An  
Coimisiún  
Pleanála

**Direction**  
**ABP-320327-24**

The submissions on this file and the Inspector's report were considered at a meeting held on 19/11/2025.

at Kippure Lodge and Holiday Village, Kippure Estate, Manor Kilbride, Blessington, County Wicklow is or is not development or is or is not exempted development:

Structure 02

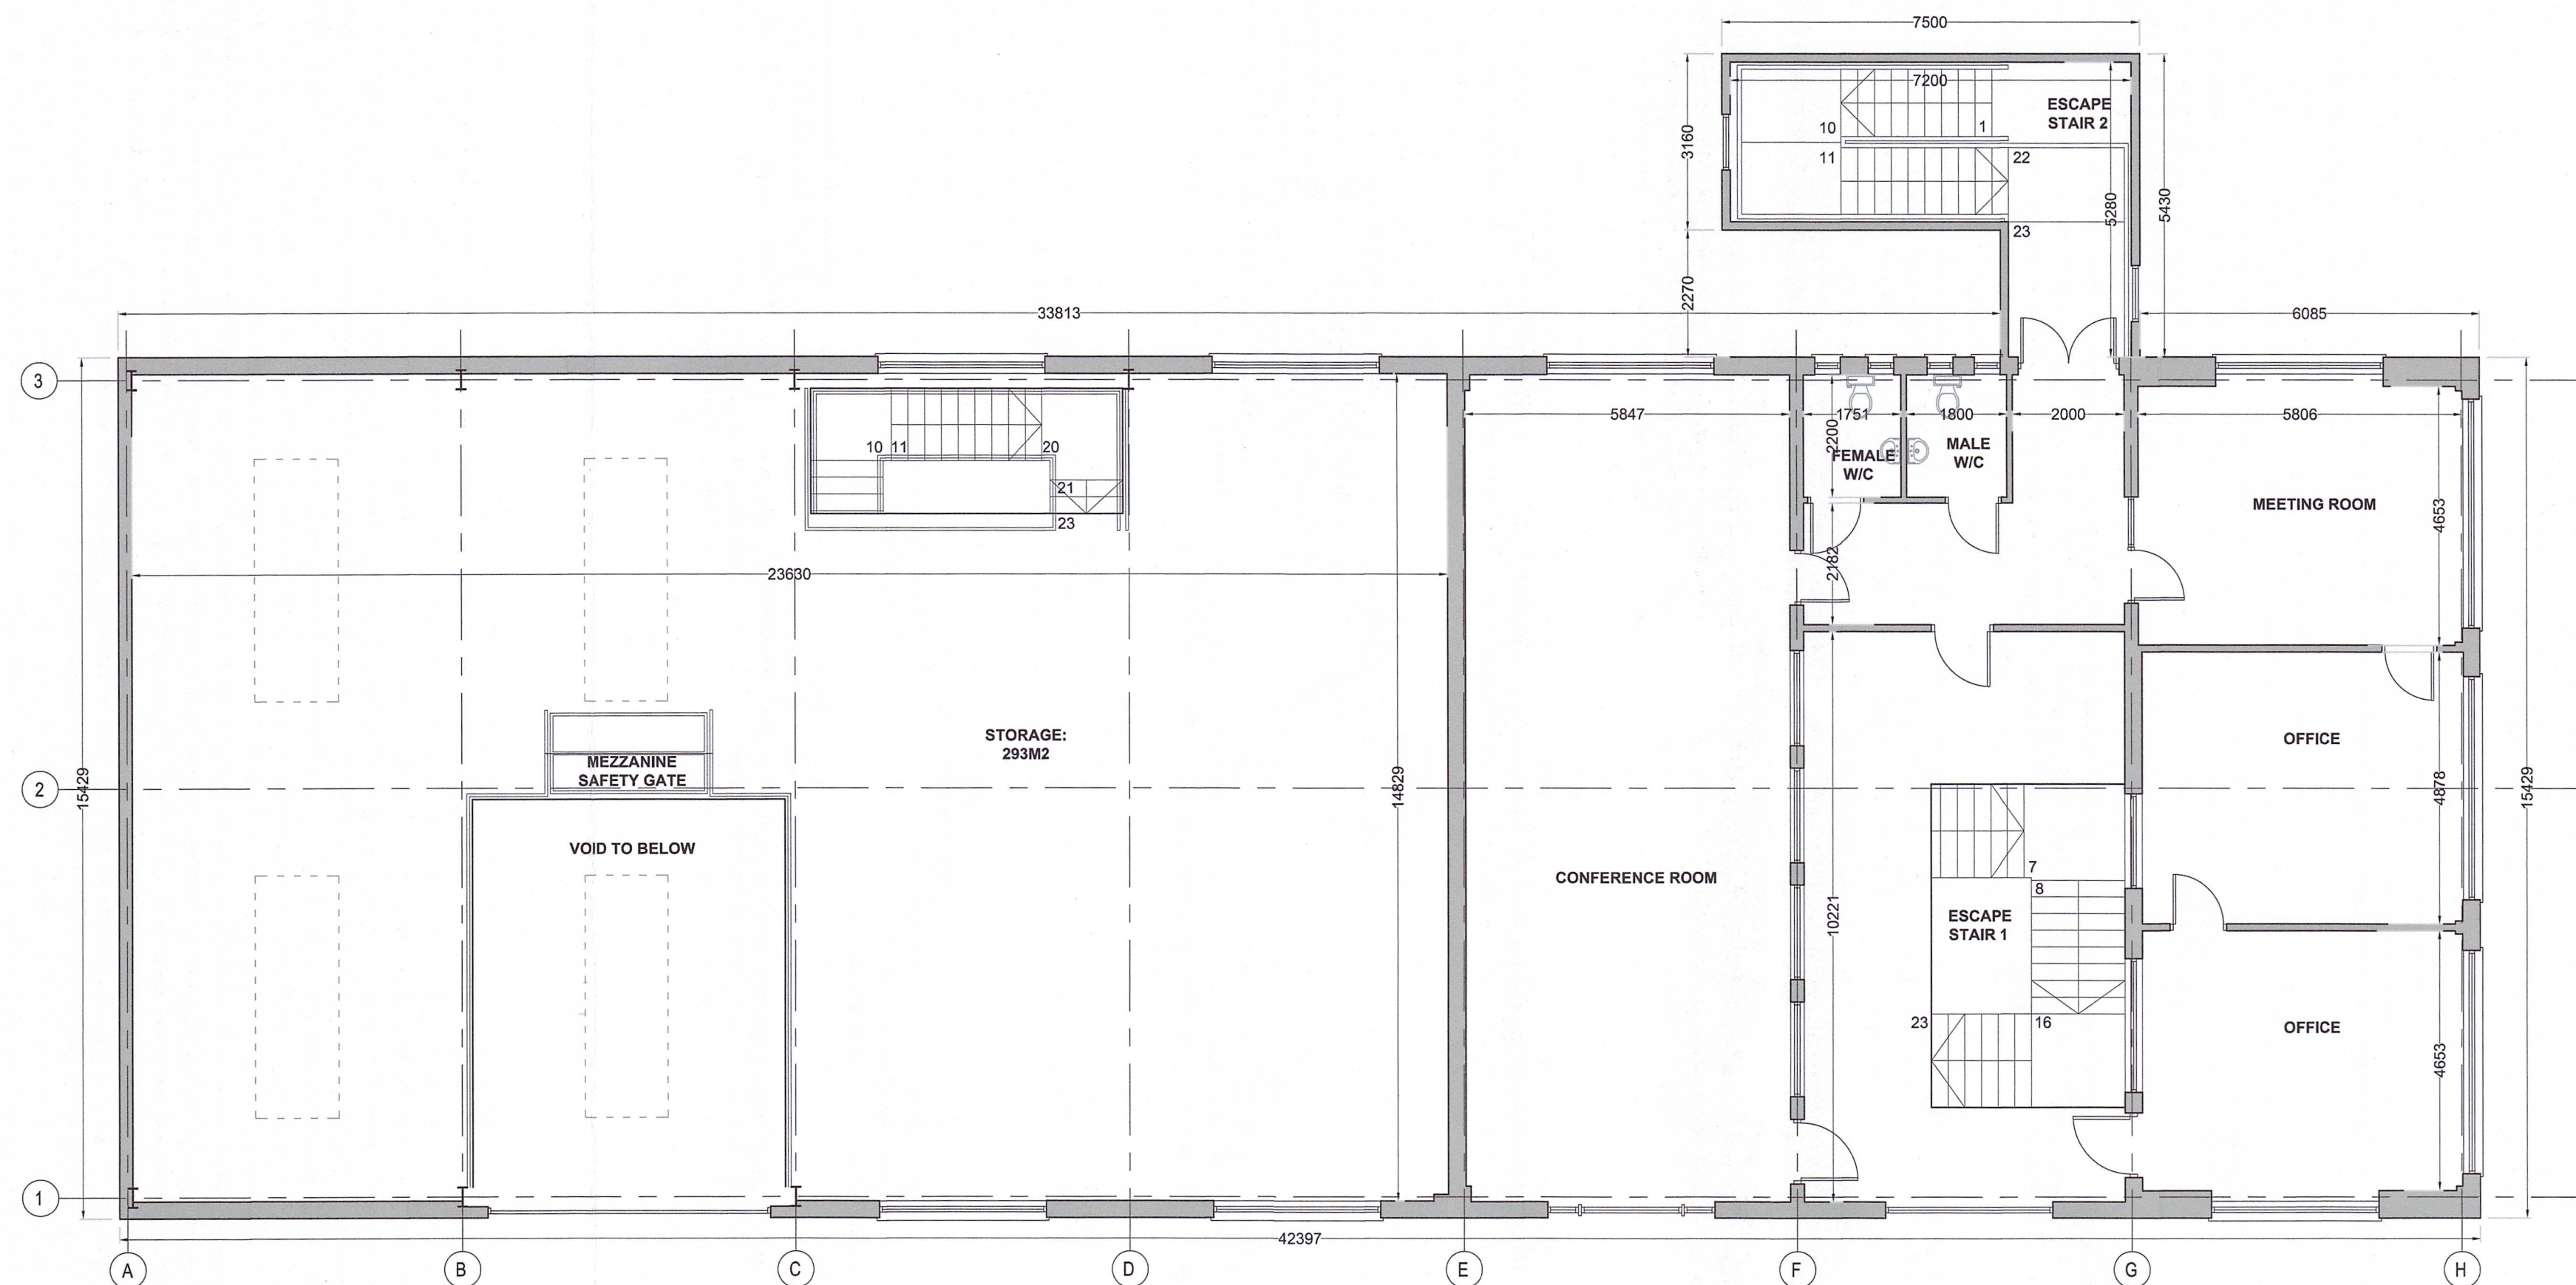
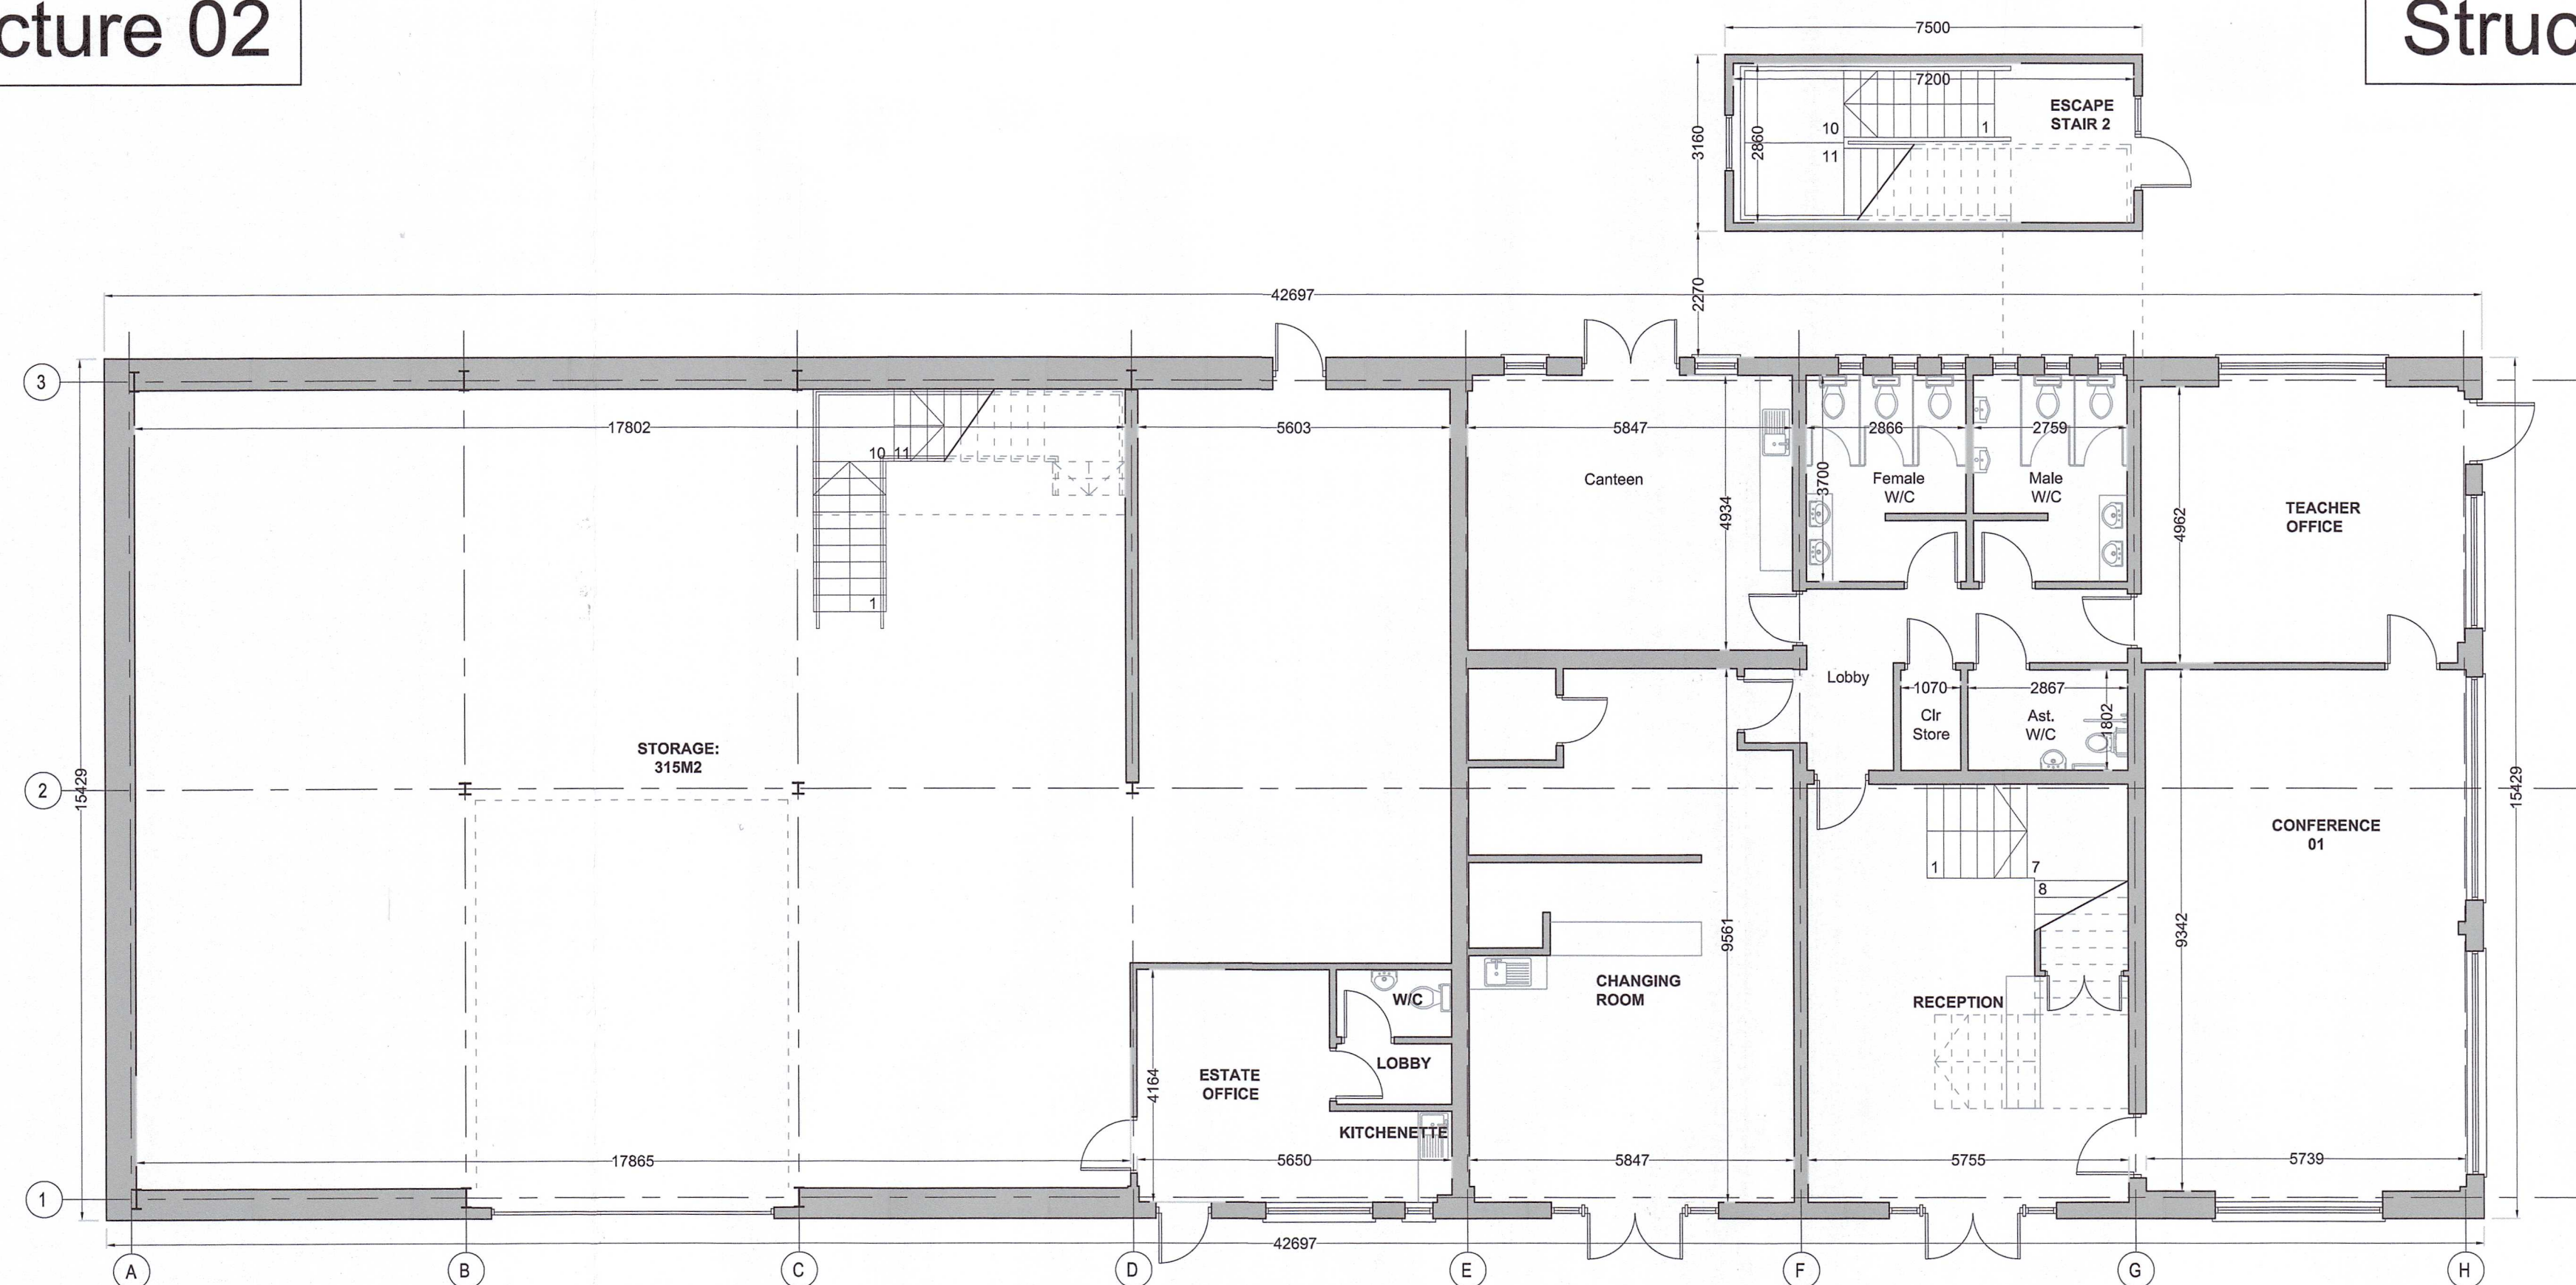
- (b) Structure Number 2: Semi-detached agricultural storage facility does not fall within the scope of Class 9 of Part 3 of Schedule 2 of the Planning and Development Regulations, 2001 (as amended) as the use of the structure for agriculture or forestry has not been adequately demonstrated. The structure has a gross floor area that exceeds the 300sqm limitation and the aggregate gross floor space of the structure, with other such structures within 100 metres, exceeds the 900 square metres limitation. Therefore, this structure does not constitute exempted development.

- (f) Structure Number 6: Former agricultural building, now used to accommodate protected persons does not fall within the scope of Class 9 of Part 3 of Schedule 2 of the Planning and Development Regulations, 2001 (as amended) as it has a gross floor area that exceeds the 300 square metres limitation. In addition, the aggregate gross floor space of the structure, with other such structures within 100 metres, exceeds the 900 square metres limitation. Therefore, this structure does not constitute exempted development. This structure does not fall within the scope of Class 14(h), (i) or (j), or Class 20F of Part 1 of Schedule 2 of the Planning and Development Regulations, 2001 (as

amended) as there is no exemption for a change of use from agriculture to accommodation or an emergency reception and orientation centre for protected persons. In addition, the referrer has not demonstrated that this structure was constructed on behalf of the Minister for Children, Equality, Disability, Integration and Youth. No evidence that Structure Number 6 was carried out in accordance with the provisions of the European Union (Planning and Development) (Displaced Persons from Ukraine Temporary Protection) Regulations 2022 (S.I. Number 306/2022). No evidence that the structure is related to accommodation for displaced persons, given the definition of such persons set out in Annex 2 of the Council Implementing Decision (EU) 2022/382. Therefore, this structure does not constitute exempted development.
